TPS Transport Consultants Ltd

Transport Assessment Addendum

Client	Newett Homes
Project	Shepley Road, Stocksmoor
TPS Reference	P2835
Date Prepared	04.04.25
Prepared By	JT
Checked By	CG

- 1.1 TPS Transport Consultants Ltd (TPS) has been instructed by Newett Homes to prepare a Transport Assessment Addendum (TAA) in support of a planning application for a residential development of up to 50 dwellings on land north east of Shepley Road, Stocksmoor, Huddersfield, HD4 6XW.

Drawing: KIRKLEES REFUSE VEHICLE SWEEP PATH ANALYSIS

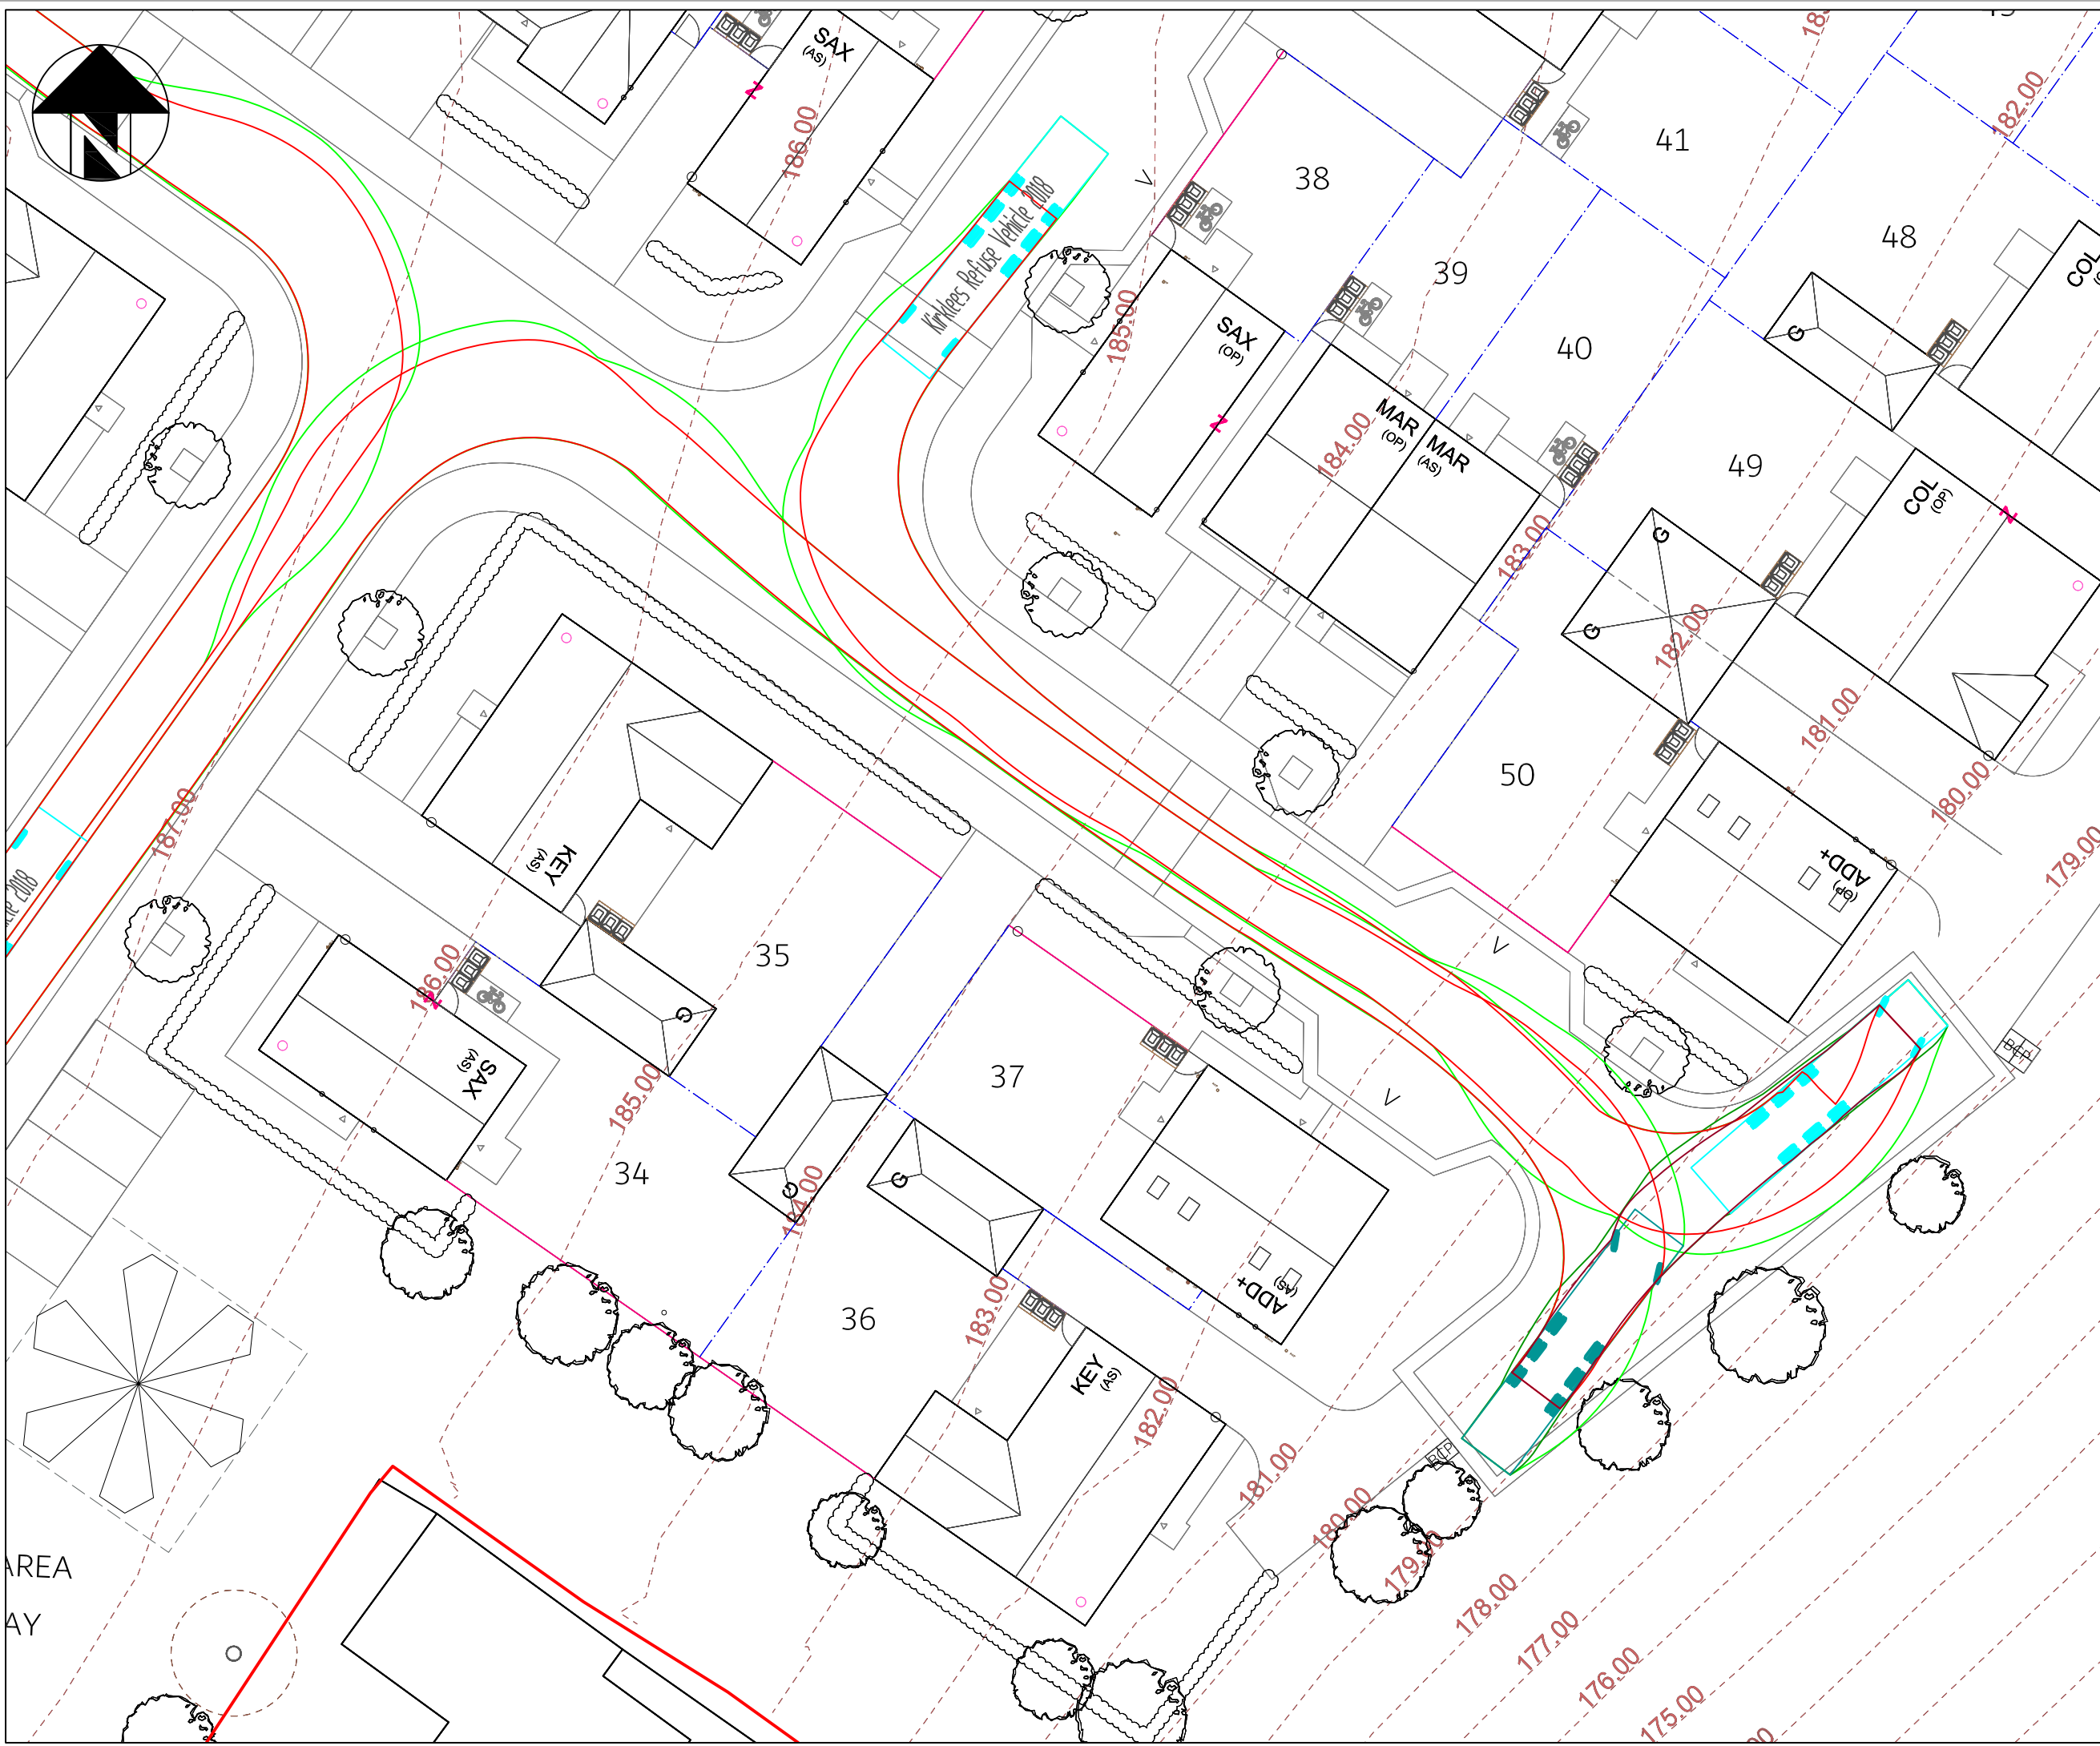
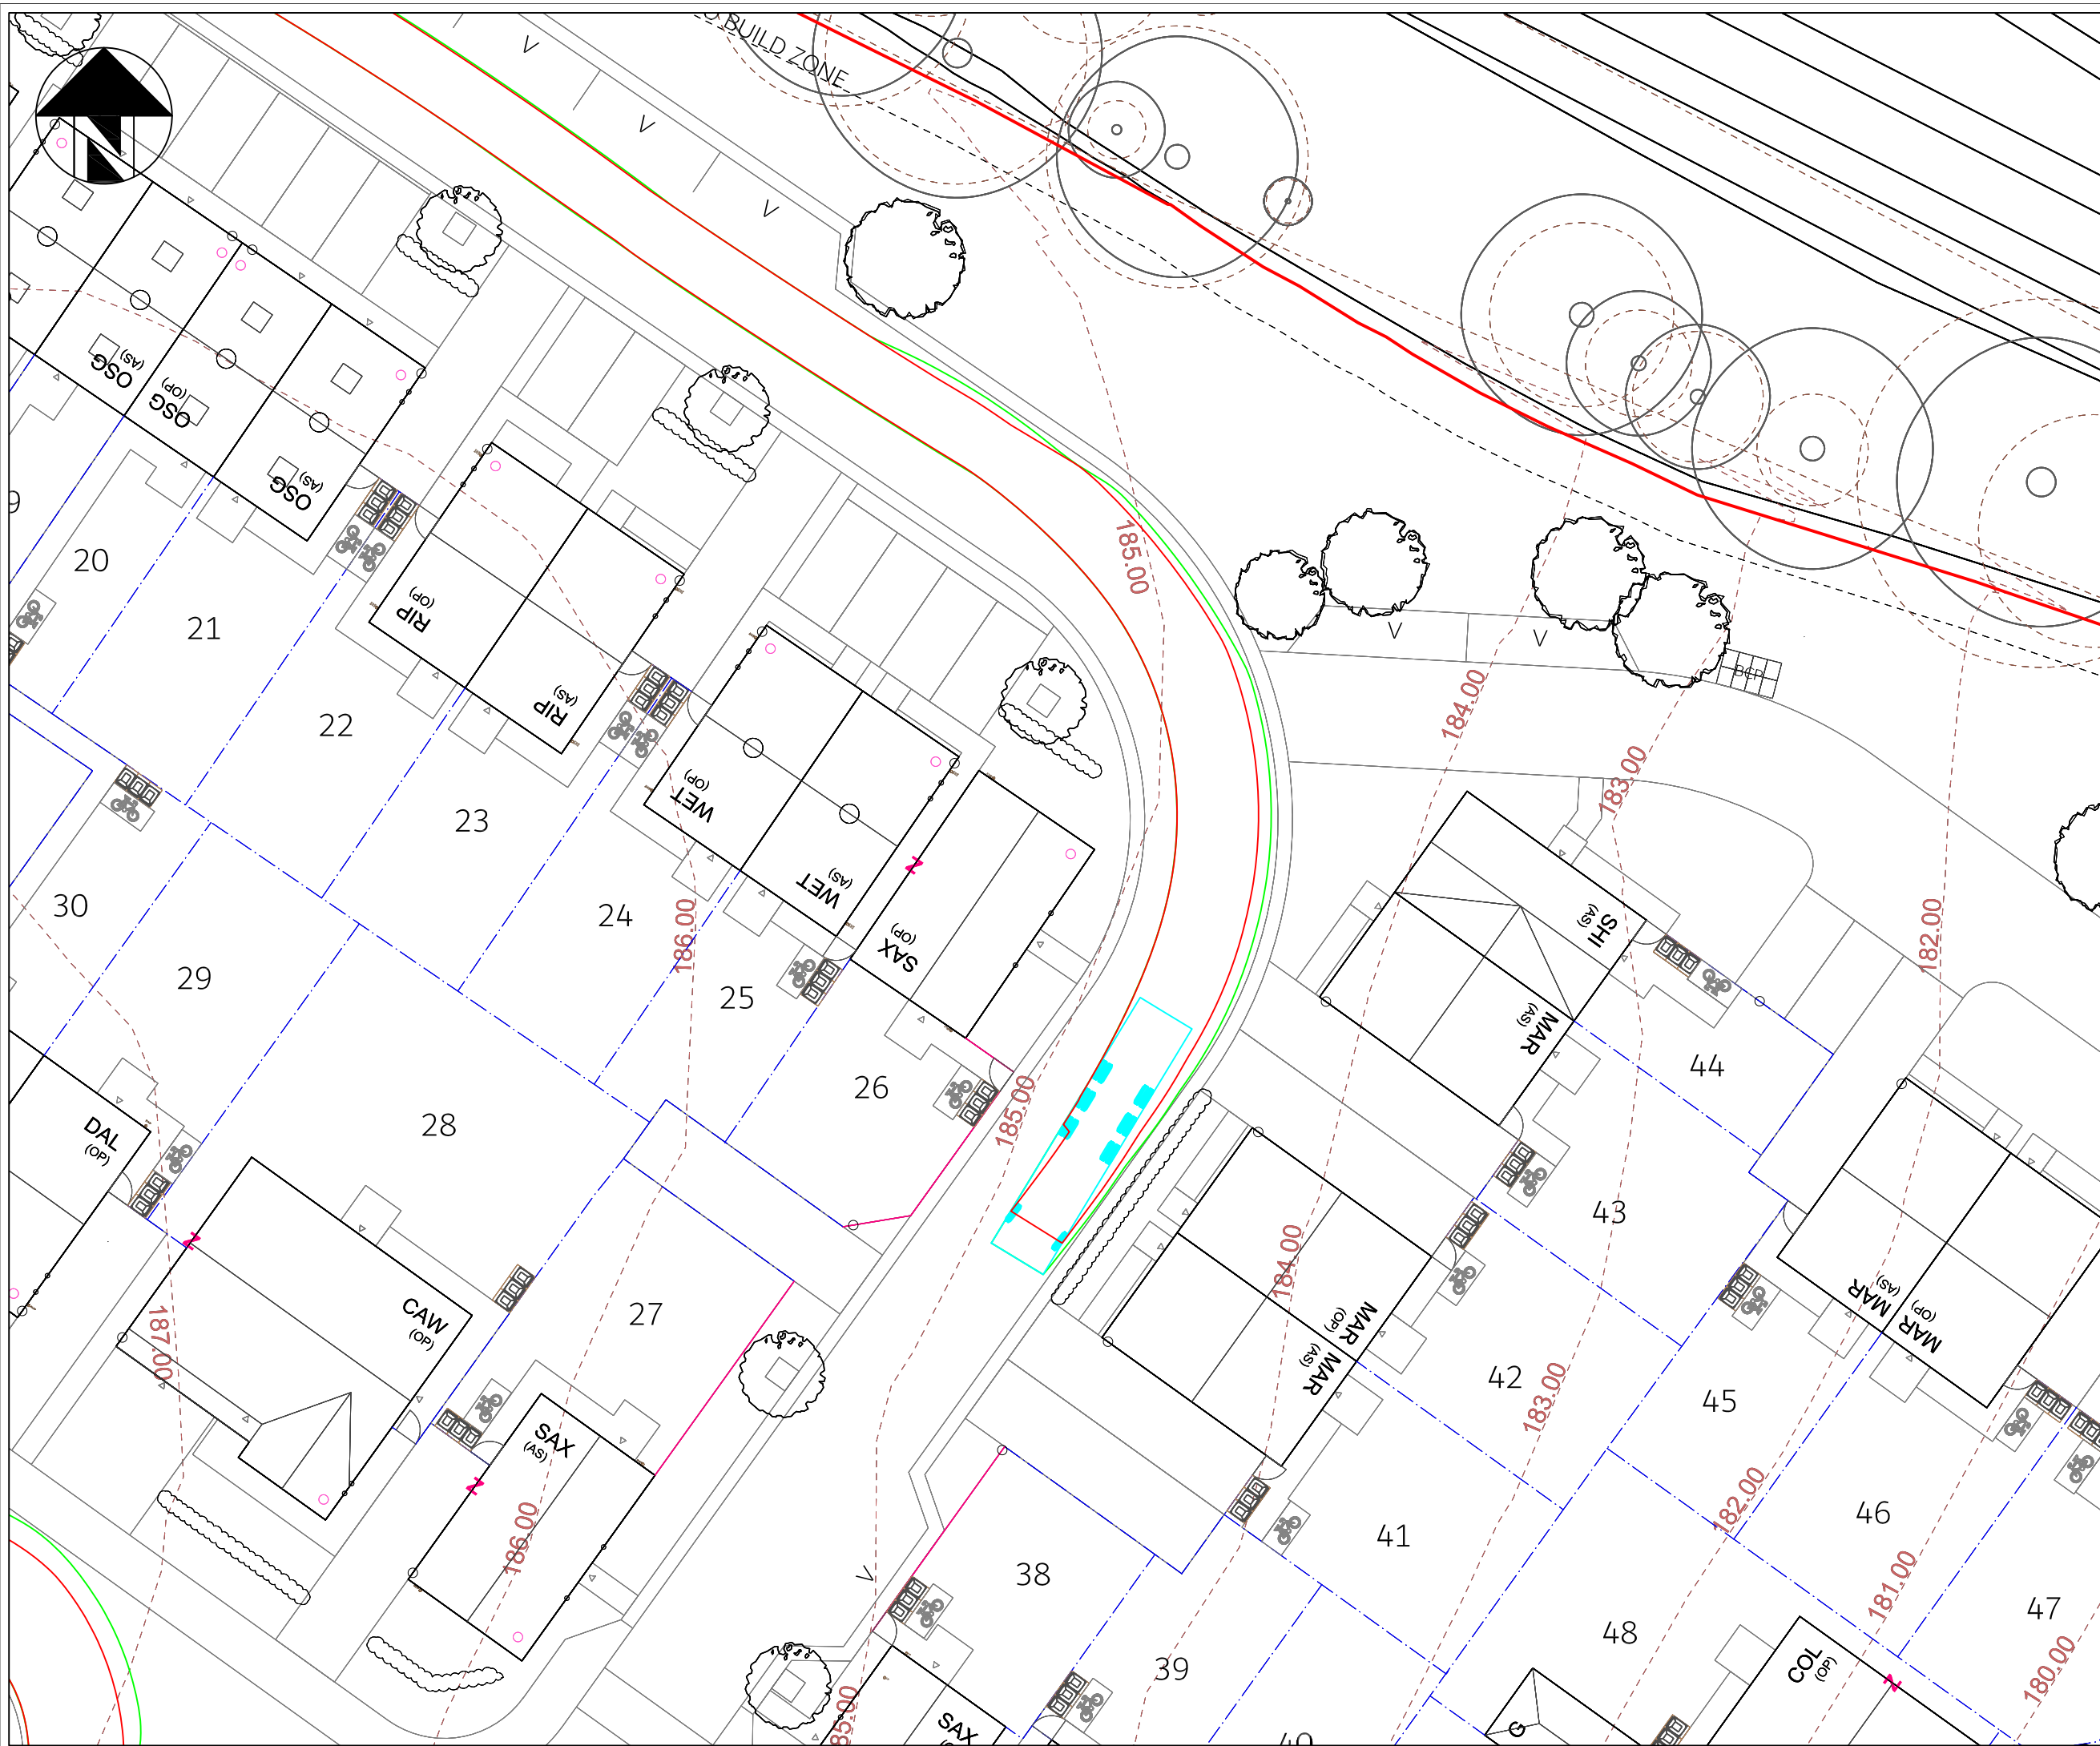
- *The proposed carriageway alignment on the southeast side of the bend appears to show the edge of the proposed carriageway immediately adjacent to the highway boundary. This should be amended to ensure that min. 600mm clearance is maintained;*

- *Block paving has been proposed in the inside of the realigned bend to protect the forward visibility splay envelope. The provision of a hard paved surface is welcomed, which should ensure that adequate visibility is maintained. However, a tarmac surface is likely to be preferred, to reduce the costs of future maintenance. The final detail of the paving type could be agreed at the S278 detailed design stage. However, the current paving proposals taper down to nothing at either end, which*

- The horizontal and vertical alignment models of the proposed site access have been updated to address comments raised in the KC consultation response and further comments provided via email. The bend has been widened to better accommodate the swept path analysis of a refuse vehicle passing a car waiting to turn right into the site. There is 0.389m clearance between the refuse vehicle and the car;
